**DEVIATION REVIEW
 AND DECISION FORM**

DEV18002

FLYING HORSE NORTH
(10% Road grade)

Section of ECM from Which Deviation is Sought: Section 2.3.2 Design Standards for Functional Classification

FLYING HORSE NORTH FILING NO. 1
STREET IMPROVEMENT PLAN
STAGECOACH ROAD
STA. 0+00.00 - STA. 15+00.00

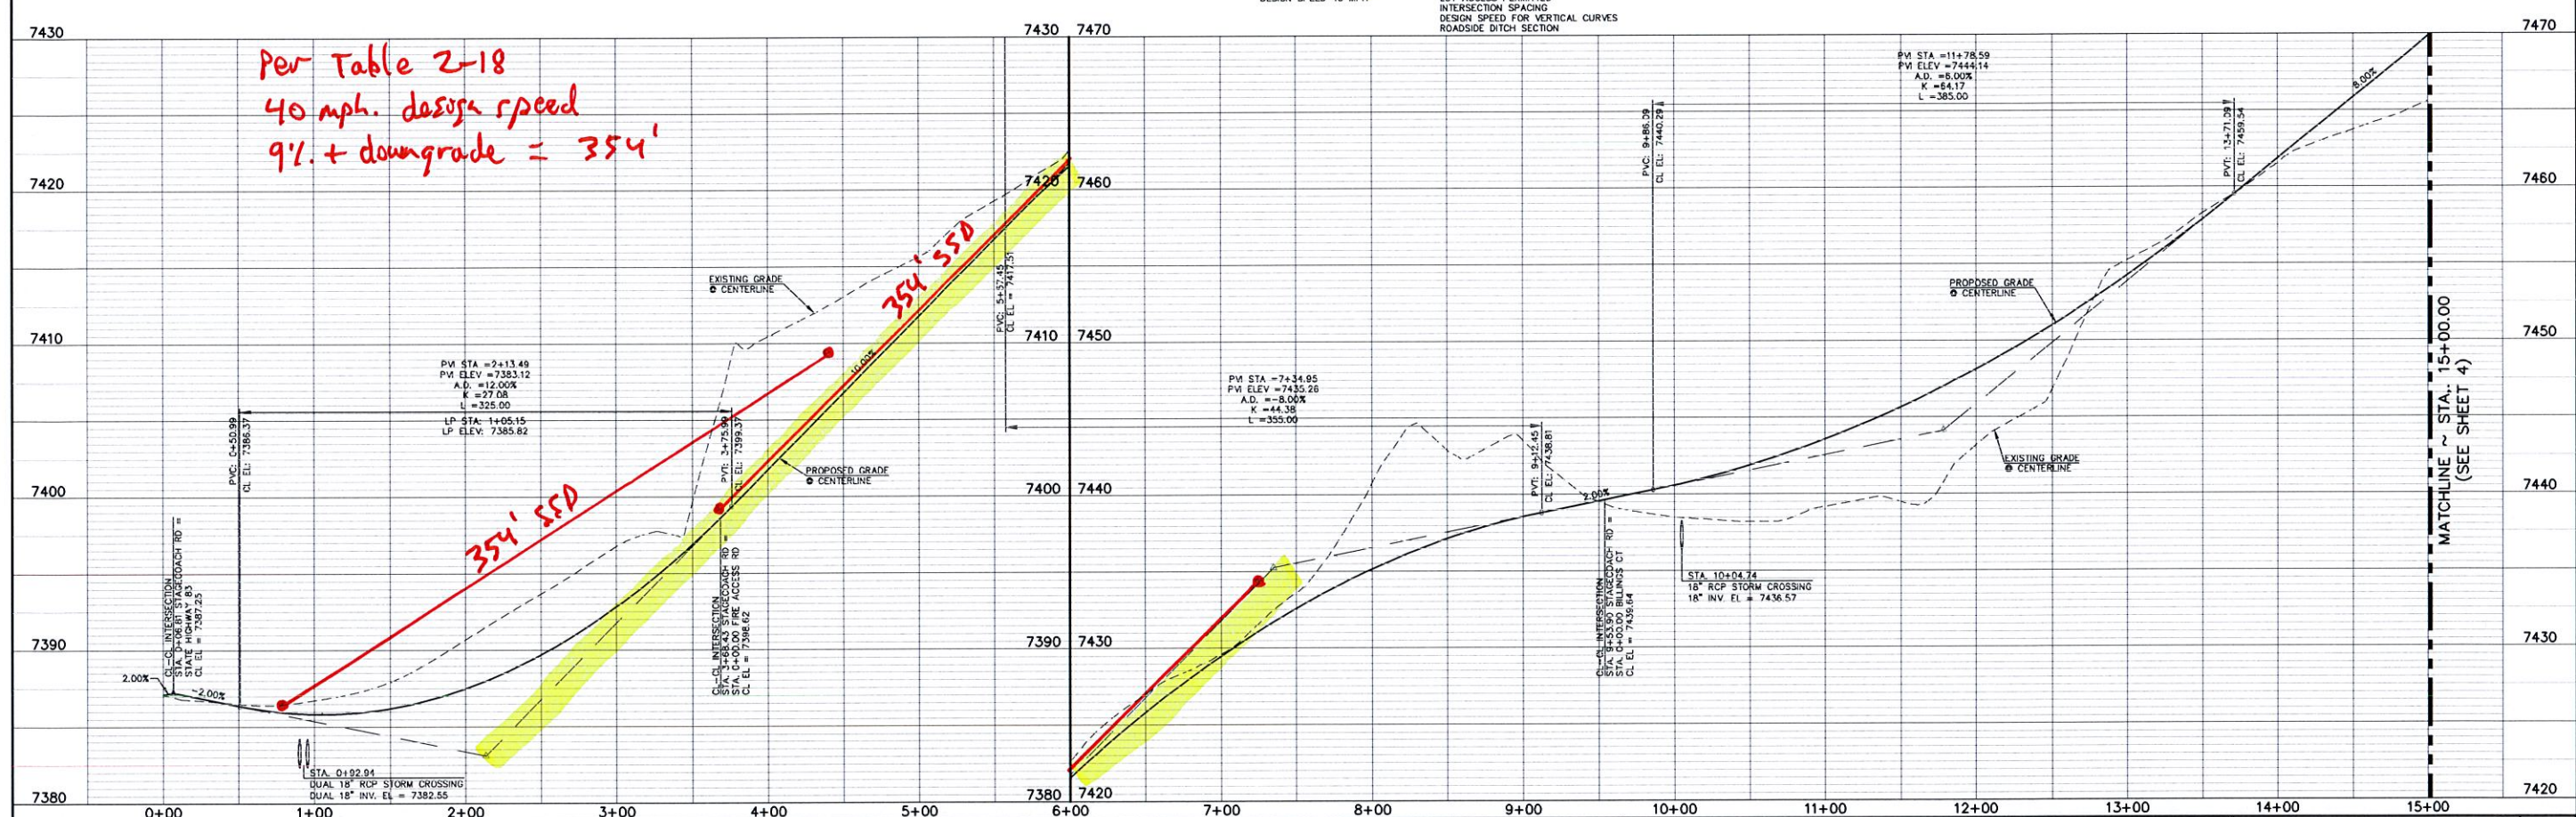
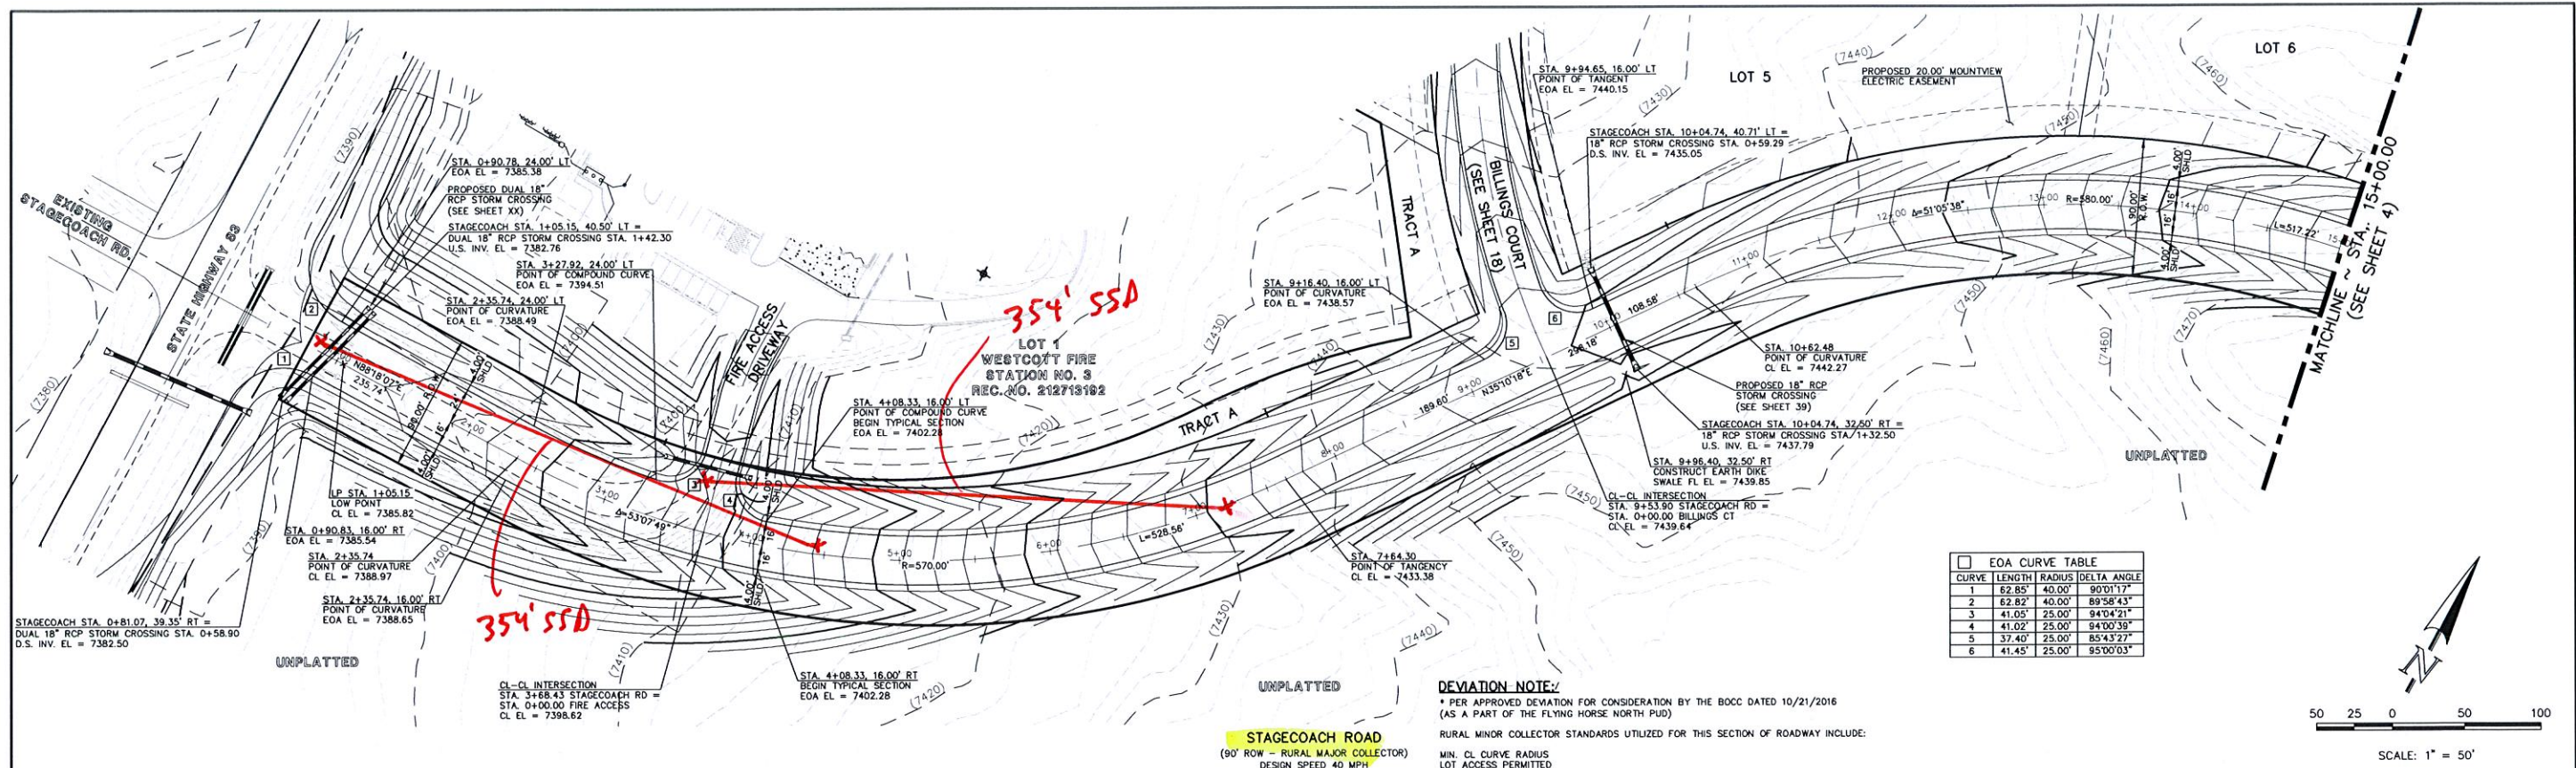
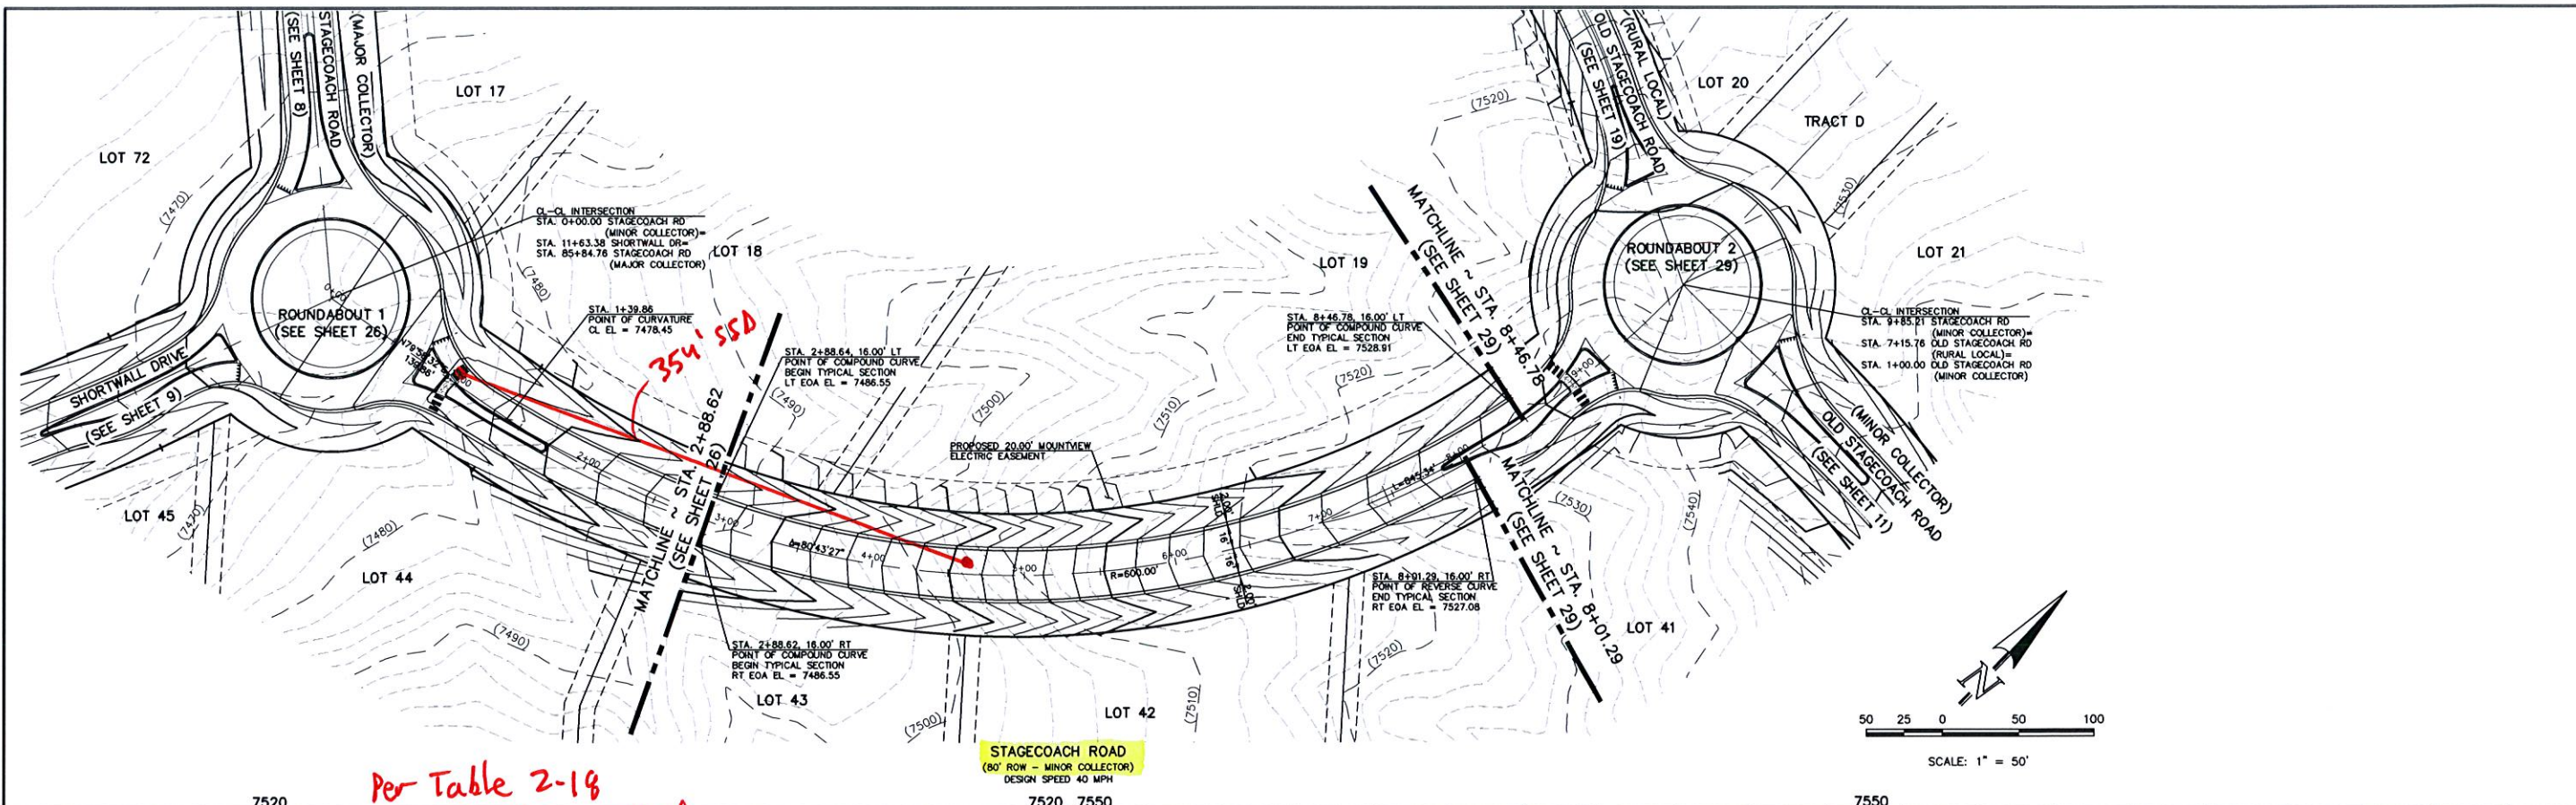
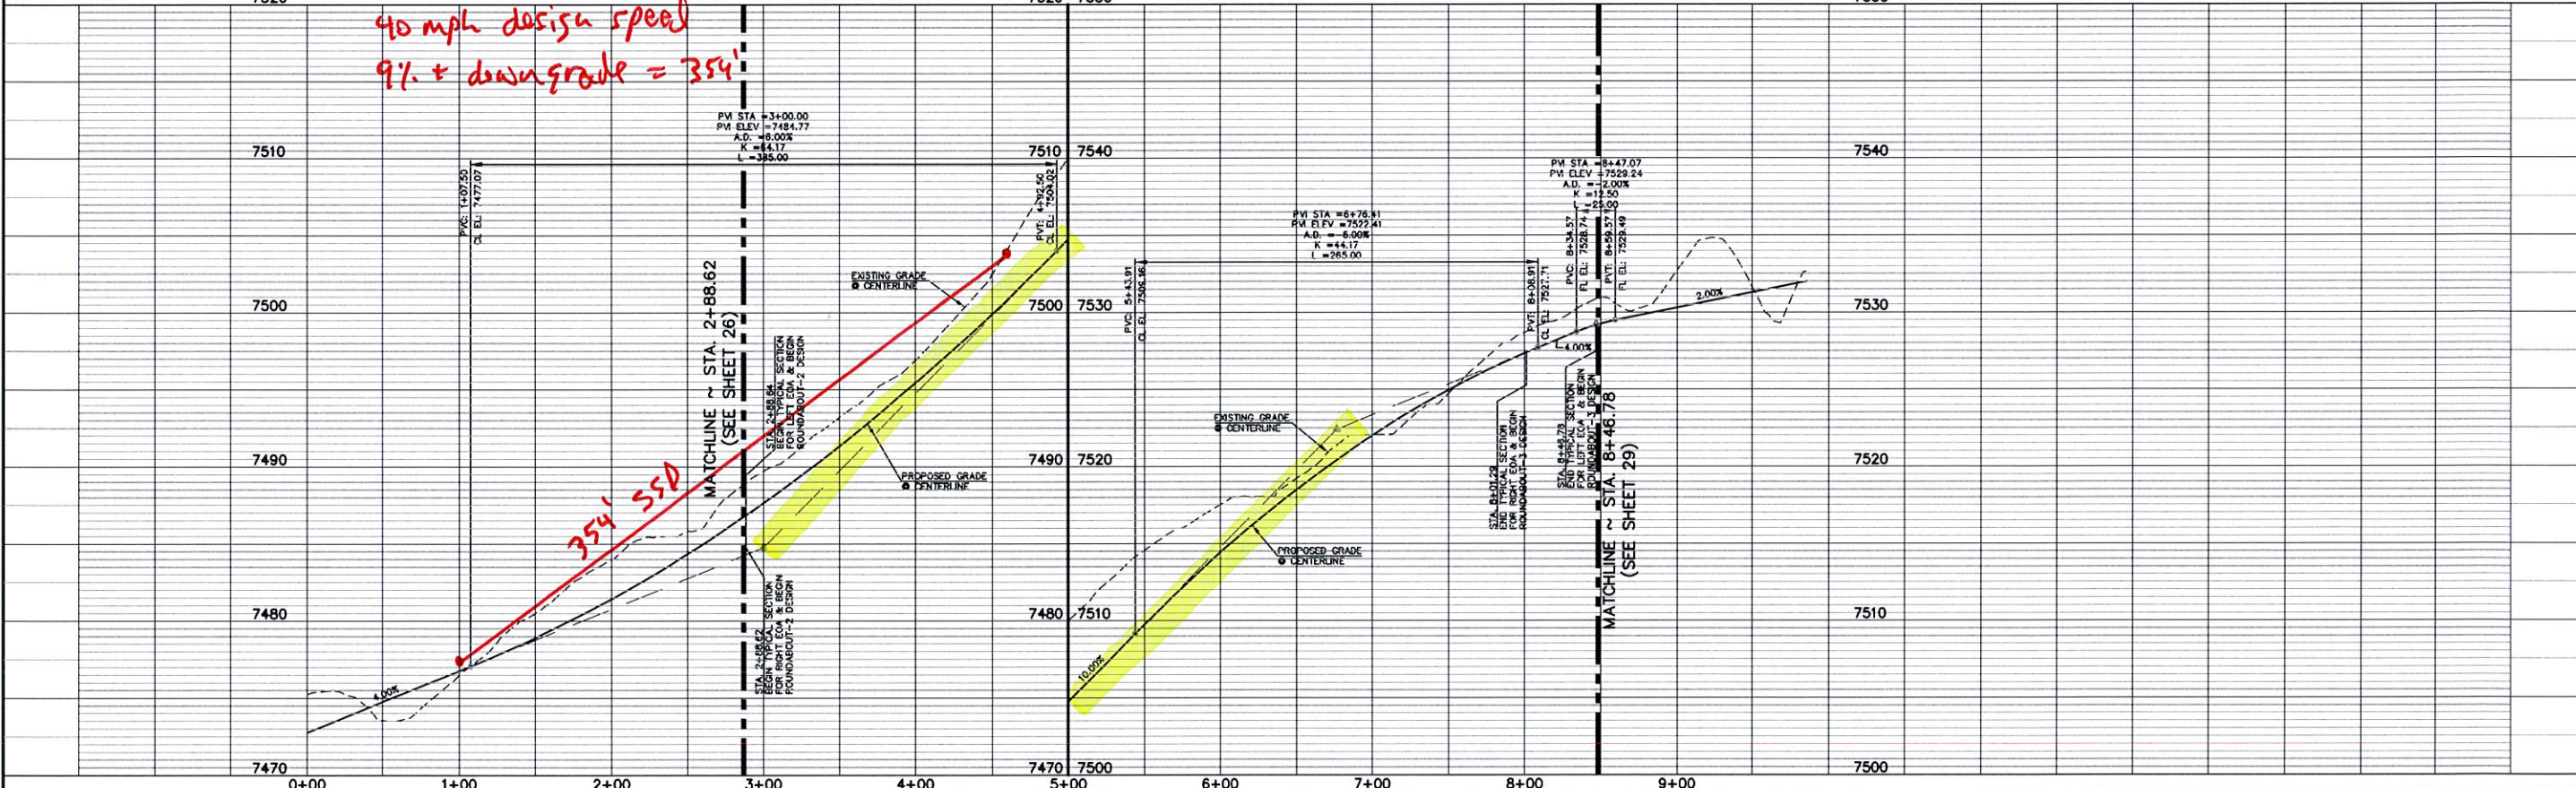
Design the length of vertical curve using adjusted K-values for the increased braking distances resulting from the downgrade (See ECM Table 2-18).

1. Provide the calculations for the required stopping sight distance for the 10% downgrades.

2. Provide calculations for the adjusted K-values based on the SSD.

2. Include a P&P of the road segment that shows the vertical curve geometry (AD, K-value, VC Length, slopes) and vertical sight distance on the profile. If it does not meet the requirement then propose how it will be mitigated.
